**Date:** 31 October 2003  
**To:** Mike Nugent  
**From:** Judy L. Johnson, AIA  
**Job #:** 03087  
**Job Name:** 280 Fore Street  
**Re:** Foundation Permit

**From:** <JJohnson@SMRTinc.com>  
**To:** Portland.CityHall(MJN)  
**Date:** Mon, Feb 9, 2004 4:52 PM  
**Subject:** RE: 280 Fore Street - response to questions by Mike Nugent

**From:** <JJohnson@SMRTinc.com>  
**To:** Portland.CityHall(MJN)  
**Date:** Mon, Feb 9, 2004 4:22 PM  
**Subject:** 280 Fore Street - response to questions by Mike Nugent

J1 SOUTHWEST ELEVATION  
1/8"=1'-0" AE109, AE101, AE102, AE103, AE104, AE105

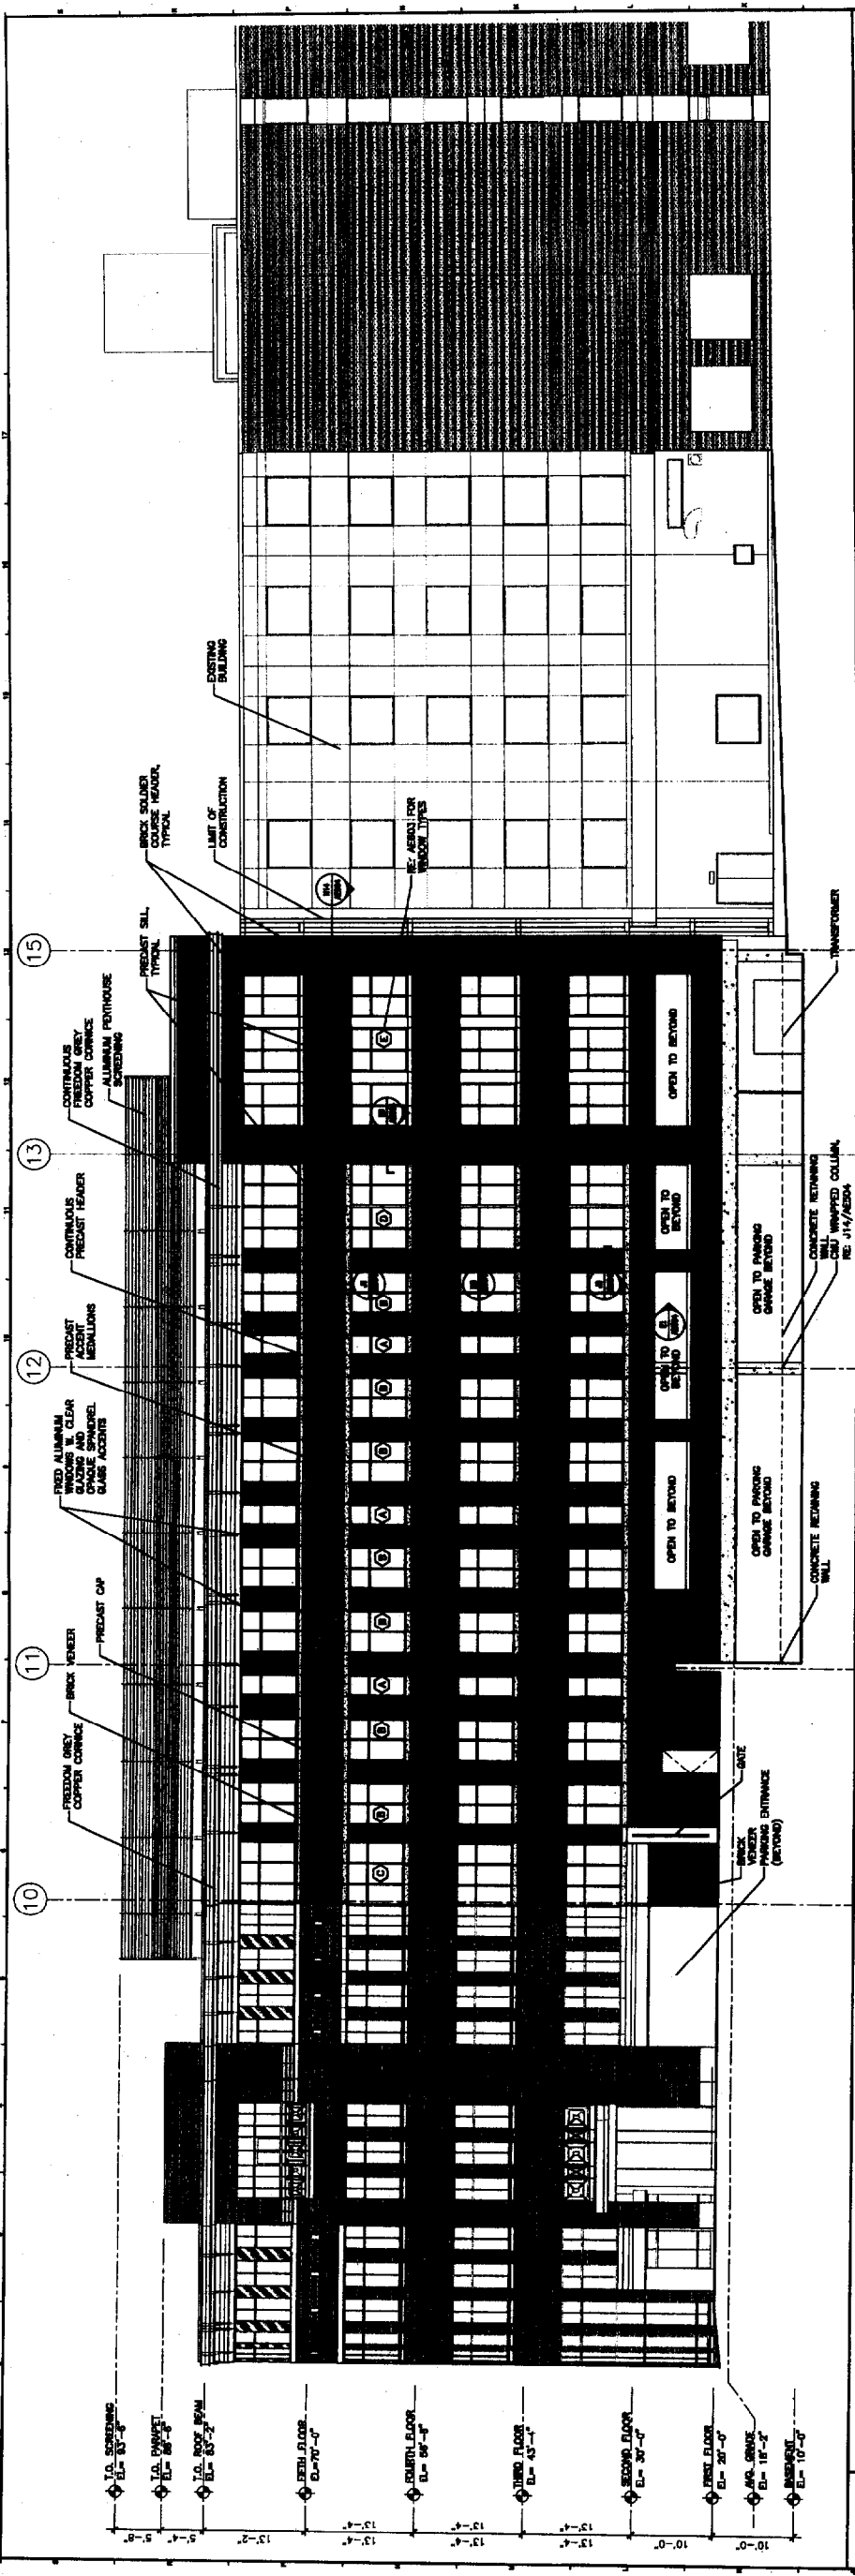
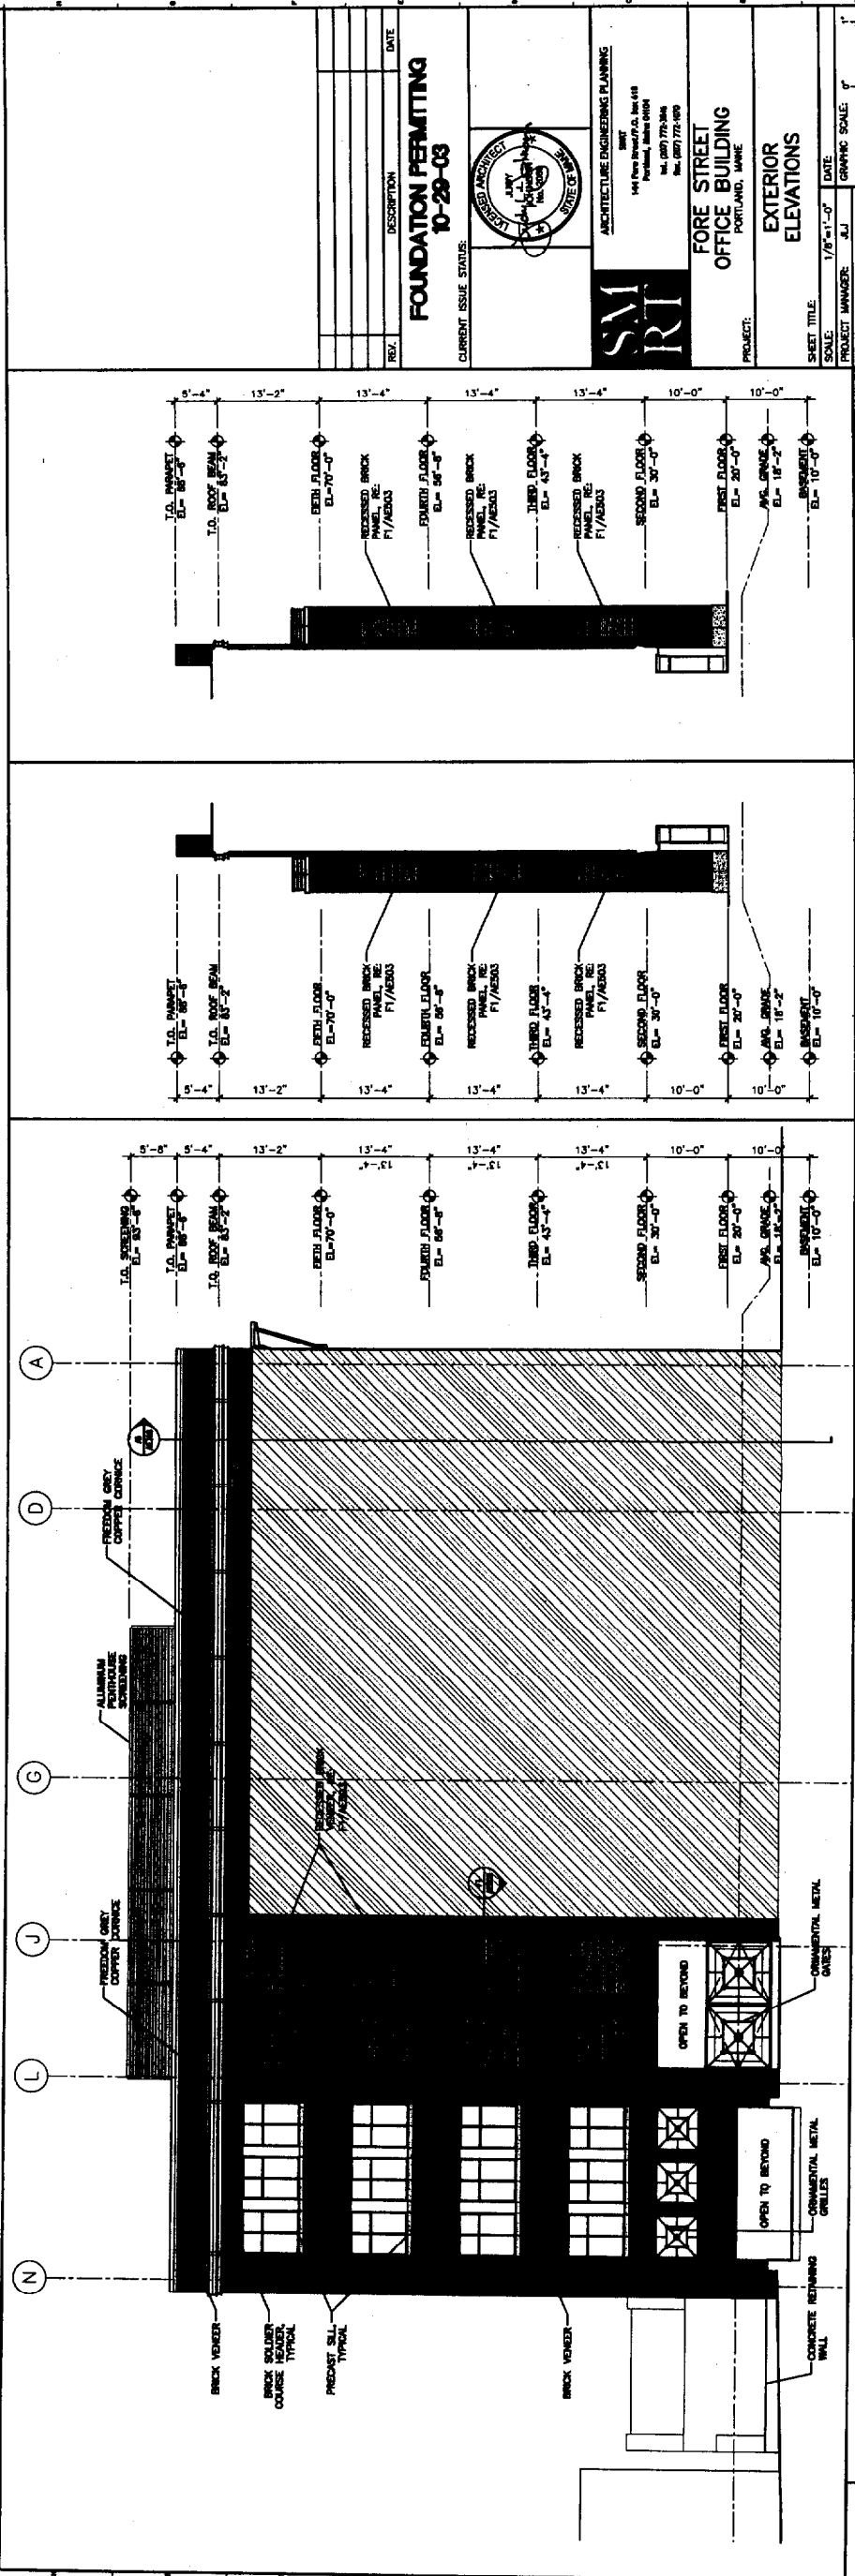
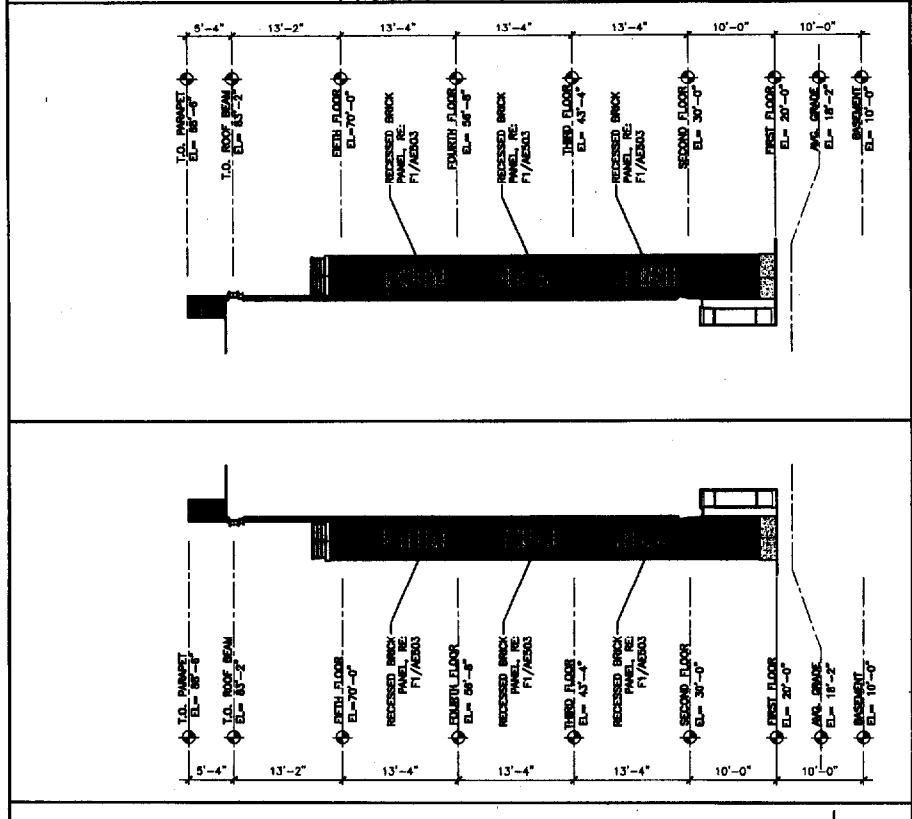
4) along the south wall, I don't think the plans do not show a parapet wall I assume we are using exception 1 in section 705.6. Can you advise? Yes you are correct Section 705.6 (exception number 1) applies.
